Your Ref : 2024/0160/DIS and 2023/0383/ LBA

Alterations, extension and renovation works to existing cottage and erection of a detached cart hovel garage. 10 Mill Lane Empingham Rutland LE15 8QE

Please find attached our resubmitted application to discharge Condition 3 of 2023/0383/ LBA.

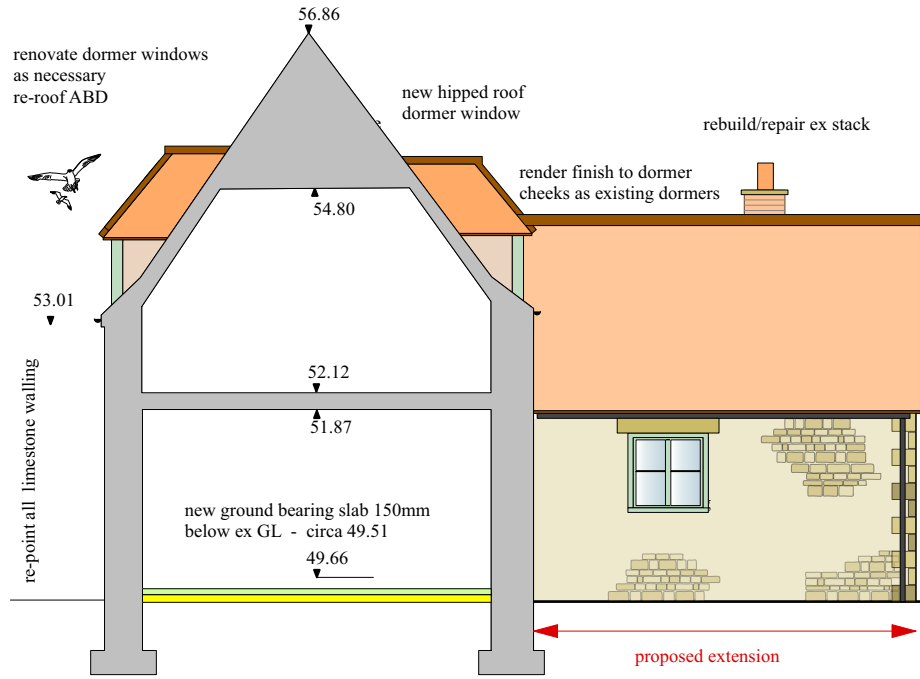
- Details of new ground floor covering to the main cottage - Refused - concrete floor not acceptable - should be limecrete mix (to ensure breathability and less harmful than a concrete floor). Use of Kingspan insulation is also not acceptable. Notwithstanding this, use of hand dig solution is acceptable.

The specification for new floors in the Cottage and Outbuilding has been revised as follows ;

New Floor to Cottage and Outbuilding

Limecrete 'slabless' system is specified. Following excavation (hand dig only allowed) to formation level, lay 100mm of RFG (Recycled Foam Glass aggregate) on a geotextile membrane on firm subsoil. DPM is not allowable. Install a geotextile membrane below and above the RFG layer. Finish with an 80mm Limecrete (or Secil NHLS 2/ 1 mix) Screed. Insert cork board perimeter insulation at abutment wall masonry walling.

Prior to the hand dig excavation for the new floor, trial holes are to be dug to expose the existing footings (and fdns) to the external stone walls to ensure that the overall floor excavation does not compromise the substructure

**Drawing Title : Proposed Joinery Details  
 Client : Mrs. R. Griffin**

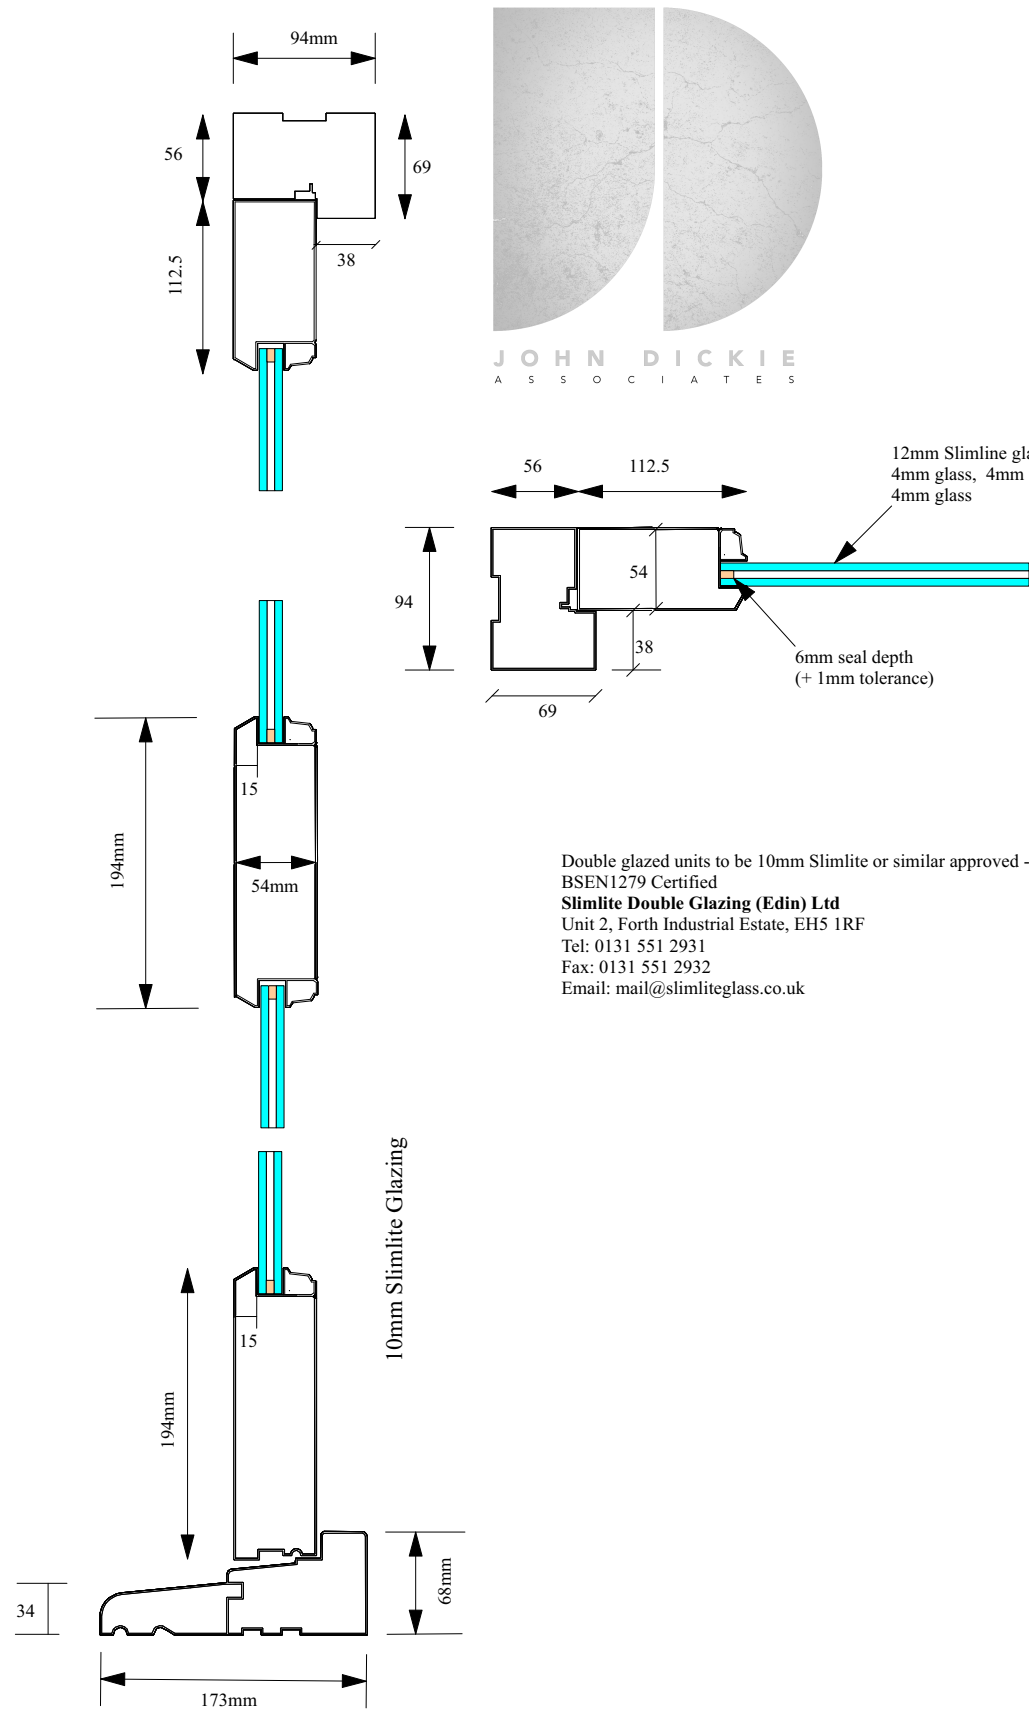
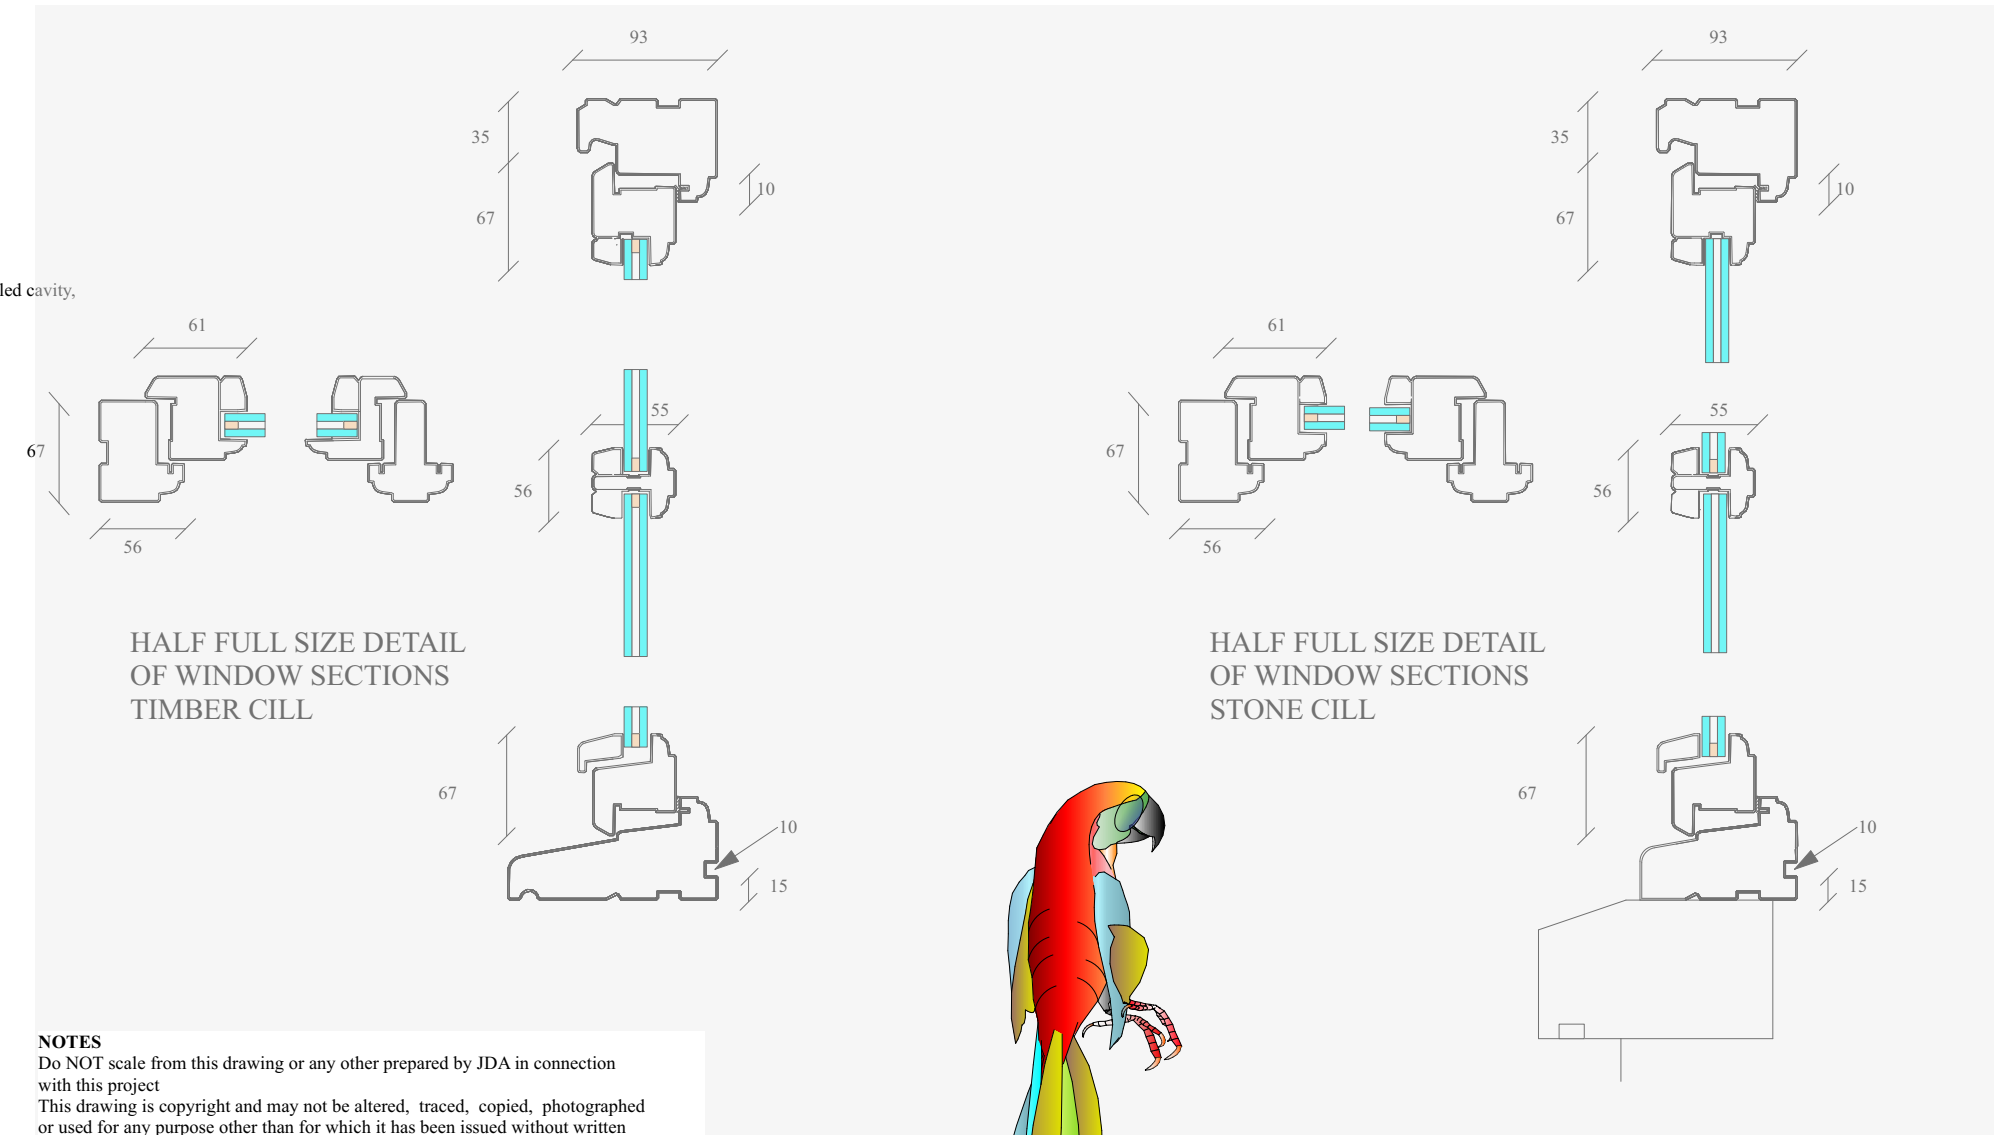
- Section details at a scale of 1:10 for the glazed link - Acceptable for the glazed link
- Section details for the new dormer windows at a scale of 1:10 - Refused - Dormer details not acceptable - not shown on joinery details and no sections details of the dormer itself.

Comment: Noted
